Longfield Solar Farm
Braintree District Council
UNR: LOSF-0003

BDC (LANDSCAPE SERVICES) Response to ExQ2 Question 2.2.3 (Veteran Oak Tree)

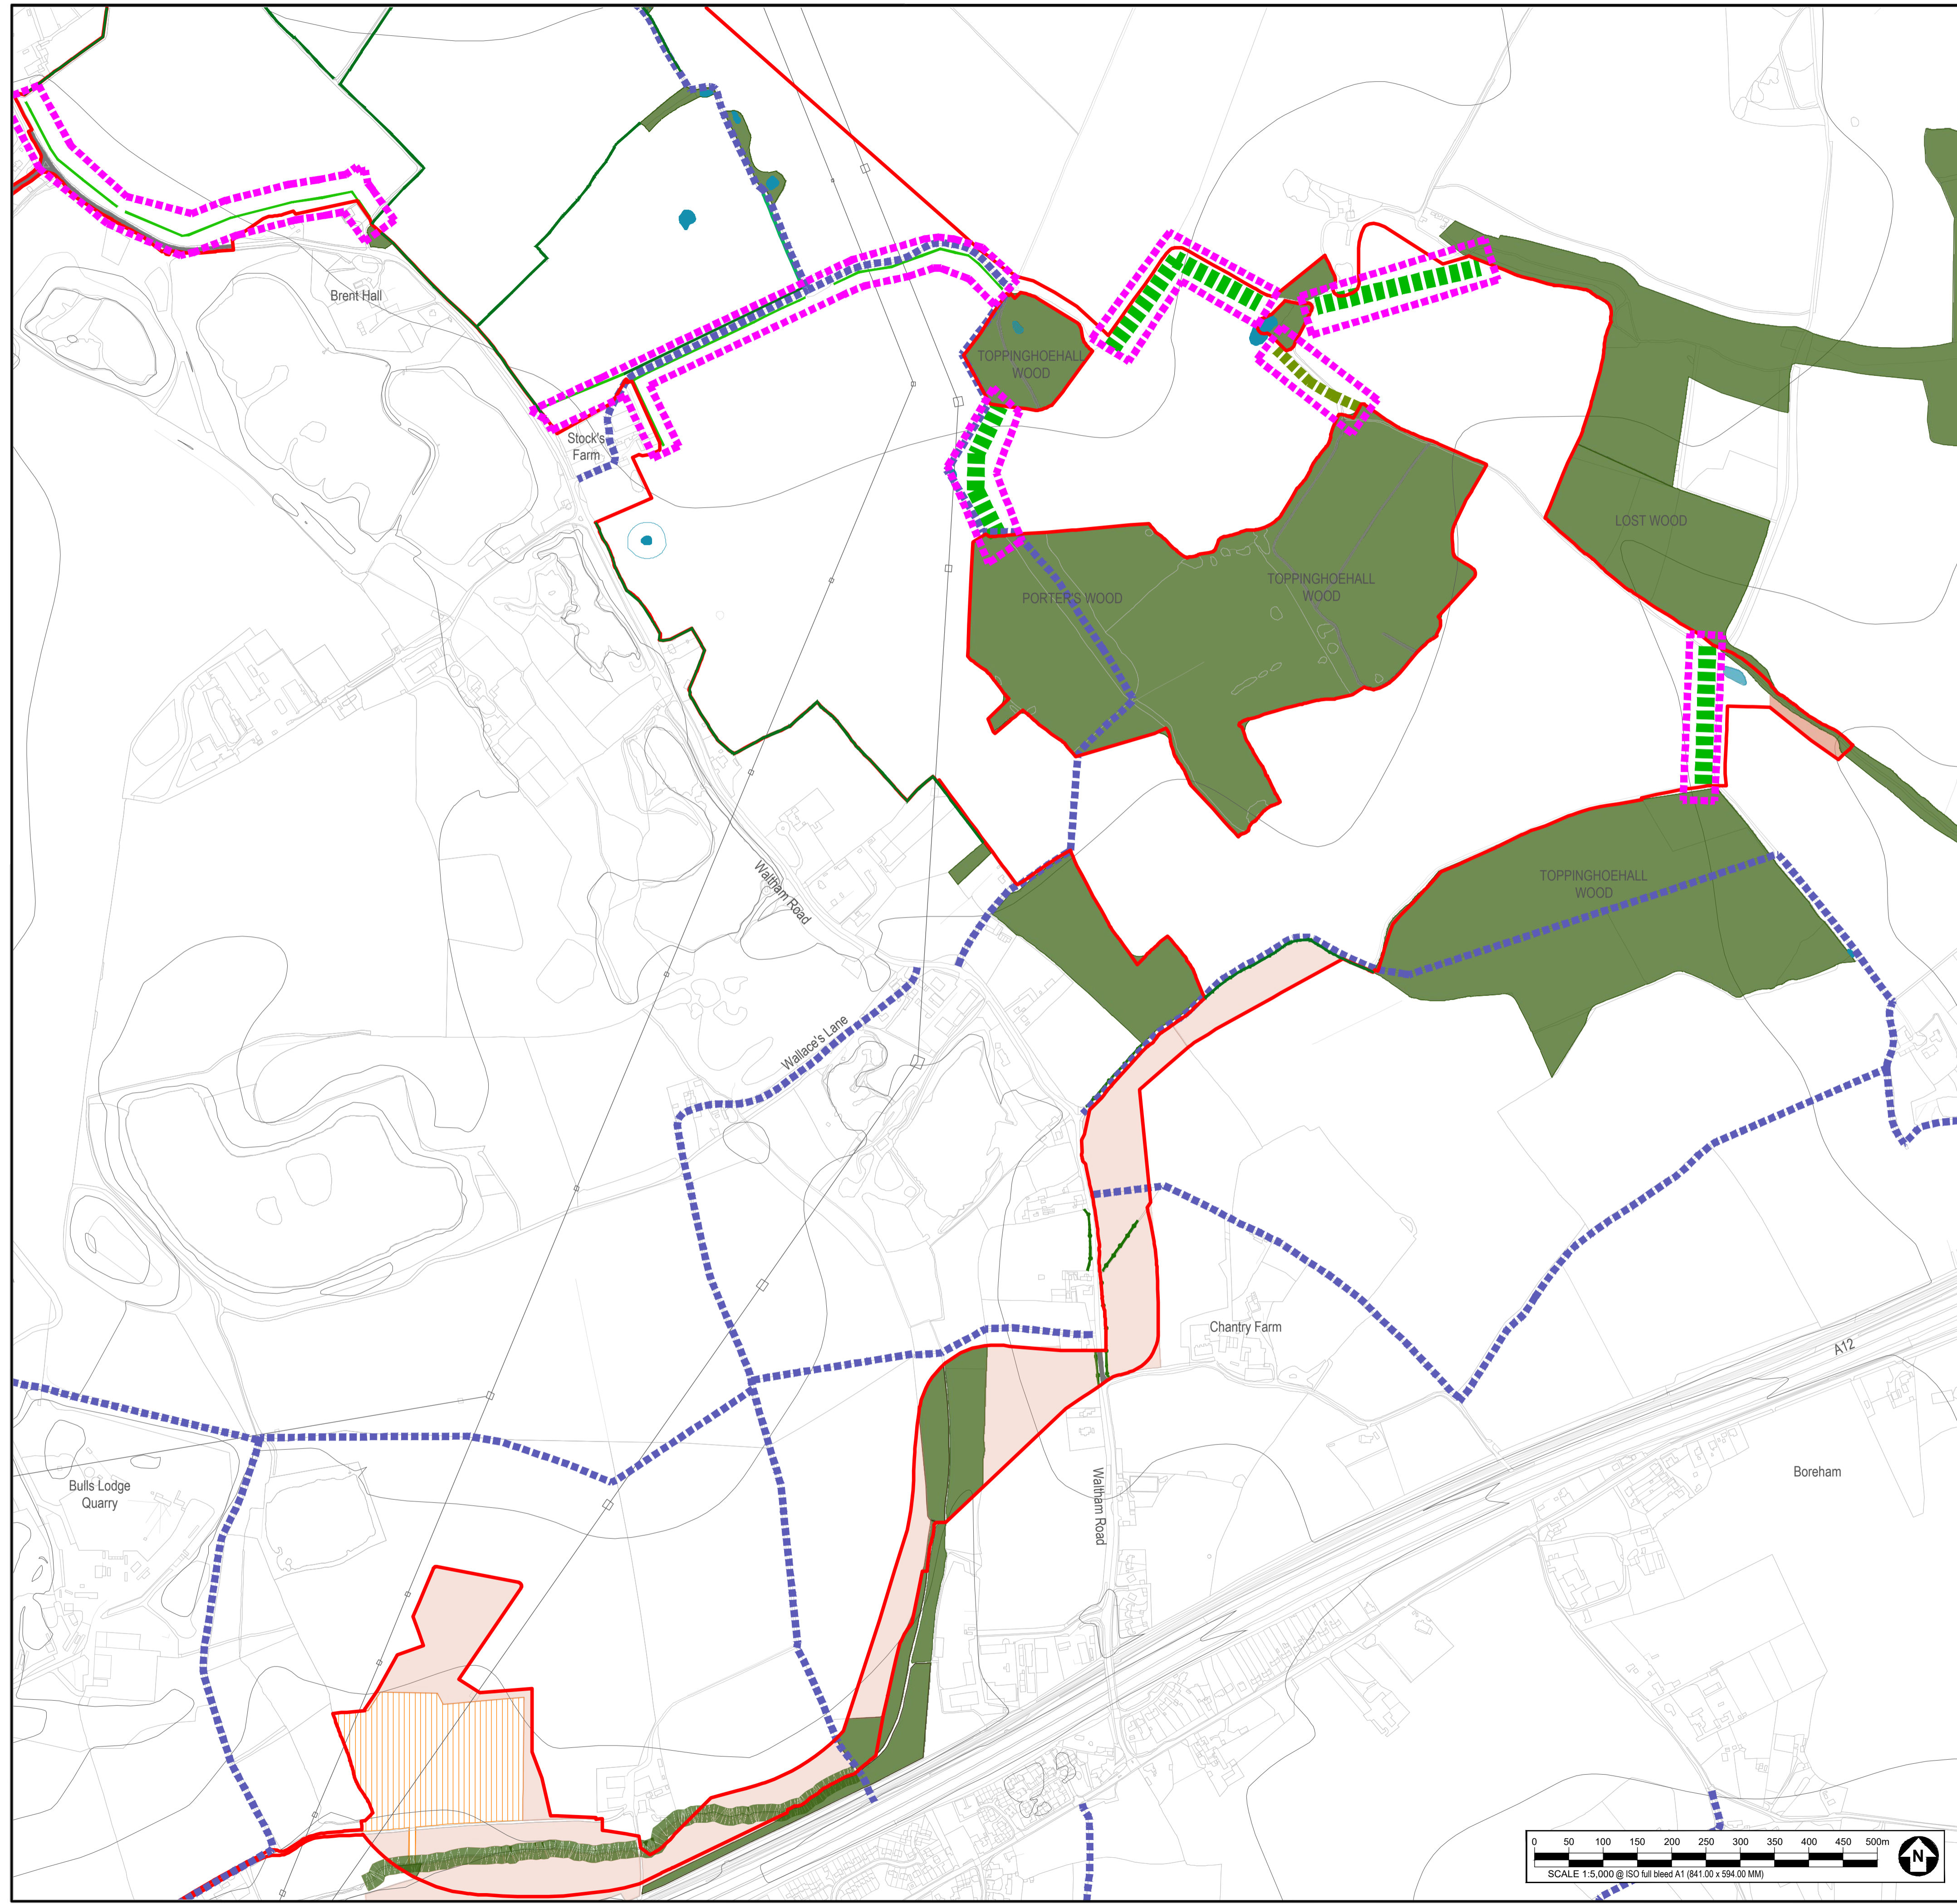
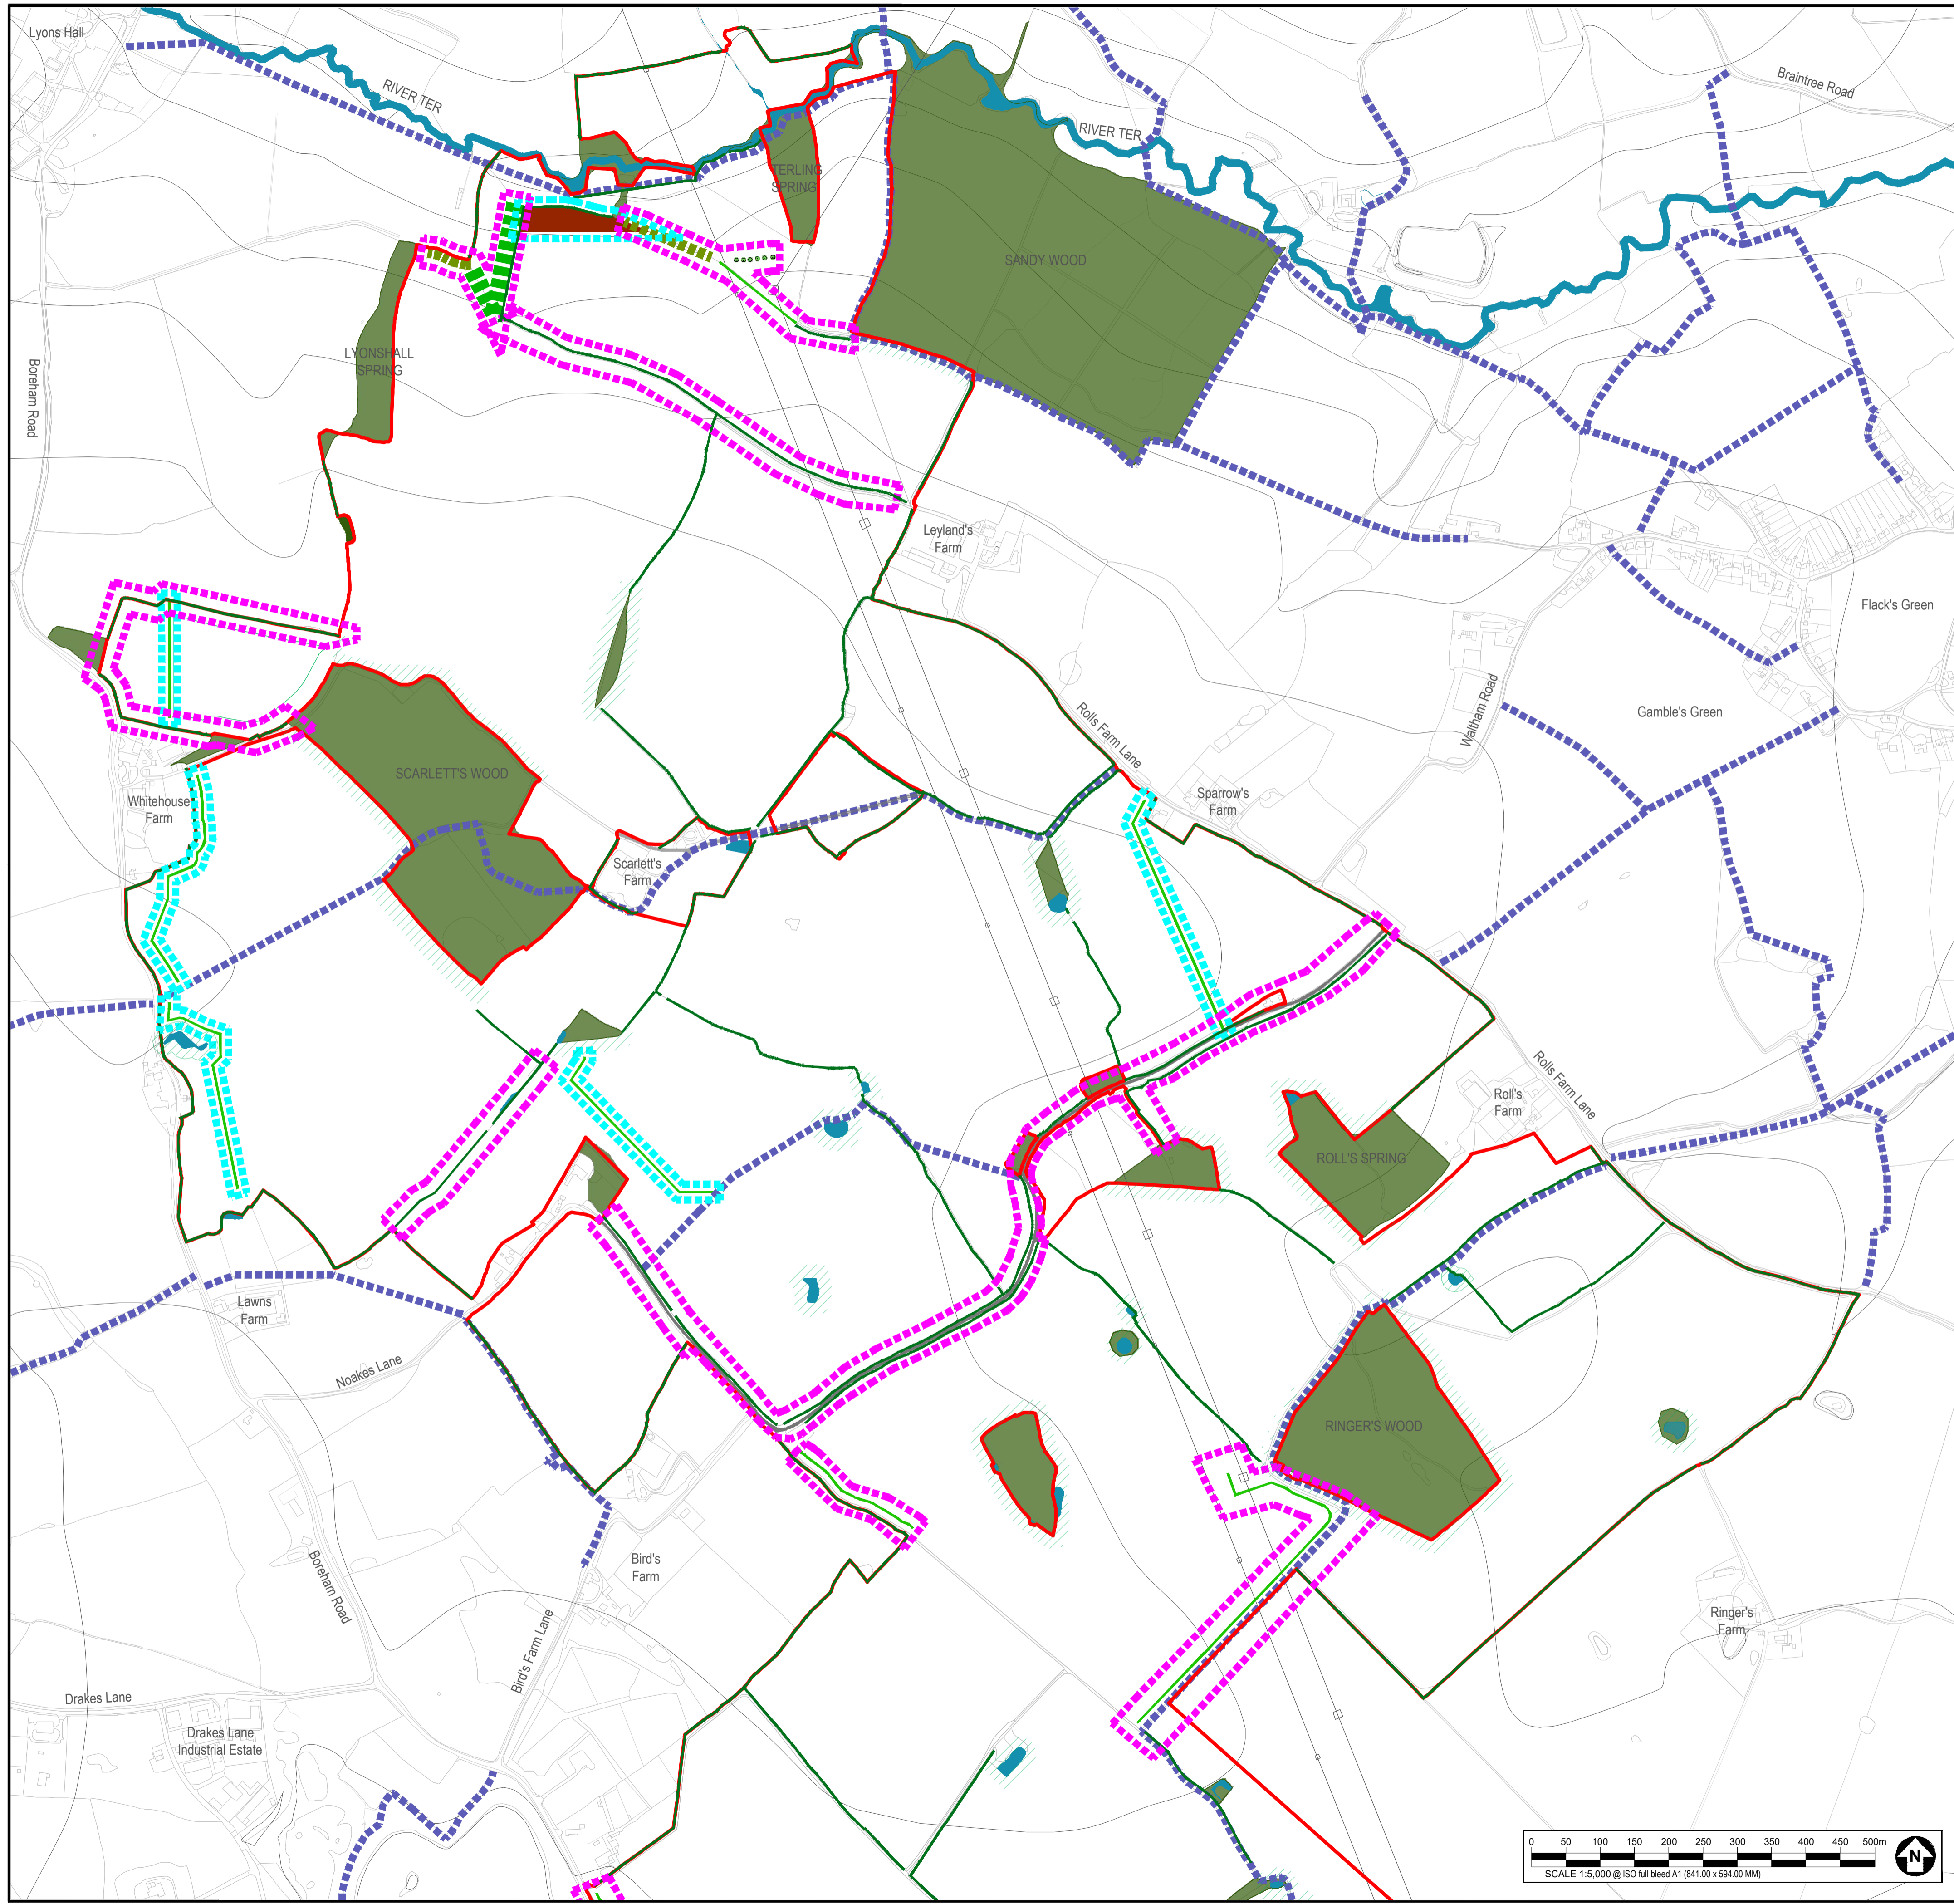
After reviewing the documentation submitted, namely the 'Arboricultural Impact Assessment (Part 1 of 2 & part 2 of 2)', the 'Illustrative Concept Design' (ARCUS), the Planning Inspectorate response, the 'Outline Landscape Masterplan – Advanced planting and Day 1 Solar Farm Construction' (AECOM), the 'Vegetation Removal Plan' (ARCUS) and the 'Biodiversity Net Gain Report' (tracked changes); BDC Landscape Services provide the following comments:

BDC Landscape Services echo these comments. The AIA suggests that the siting of the access track can be diverted around the veteran tree T9, to avoid conflict. However, there is no supporting documentation to be found to show any alteration to the track to avoid this significant tree. The vegetation removal plan shows the vegetation at the location of T9 as being removed for access, with no indication that the tree exists. The same is true of the Illustrative Concept Design, and no mention of the veteran tree can be found within the LEMP or the BNG report. Disparity is apparent and the veteran tree is being ignored.
